Town & Country Planning Act 1990 (as amended)
Town and Country Planning (Development Management
Procedure) (England) Order 2010 (as amended)
Application for Planning Permission
DECISION NOTICE

Application Ref: EG/44/14/PL

37 Stempwood Way
 Barnham
 PO22 0LA

Single storey front extension and two storey side extension; change of use from open land to garden with erection of fencing.

Proposed Ground Floor Plan

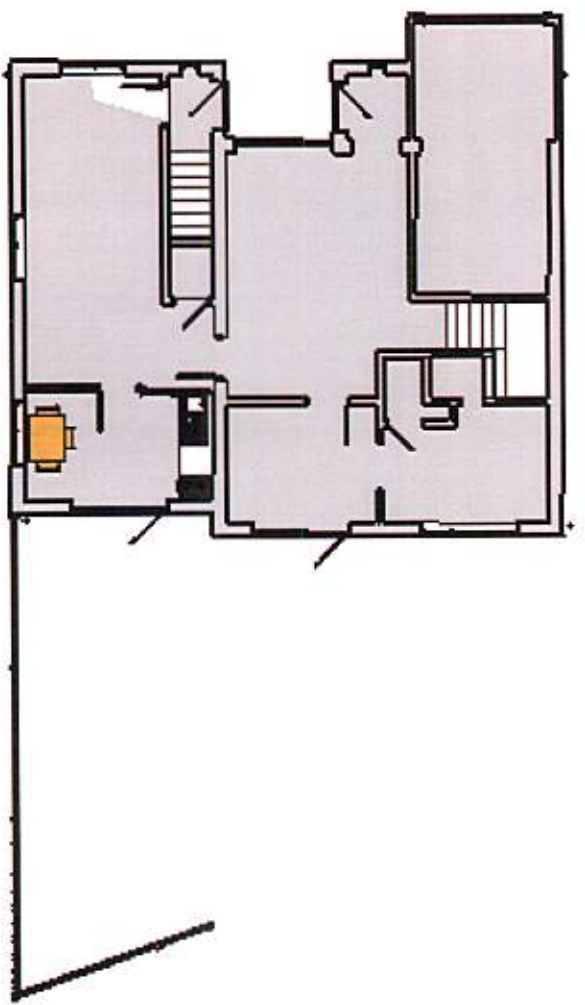
- 1 Based on the information submitted the layout and design of the proposal incorporating a separate entrance is considered tantamount to the creation of a new dwelling. The site by virtue of its size and shape is considered unsuitable to accommodate a dwelling and private amenity space satisfactorily without damaging the character of this established residential area. The proposal is therefore contrary to policies GEN7 of the Arun District Local Plan and DDM1 and DSP1 of the Emerging Local Plan and the National Planning Policy Framework.
- 2 Notwithstanding the fact that an indicative internal door is shown the proposal is considered to form a new dwelling and fails to make a contribution towards affordable housing provision and is therefore in conflict with Emerging Local Plan Policy HSP2 and the National Planning Policy Framework.
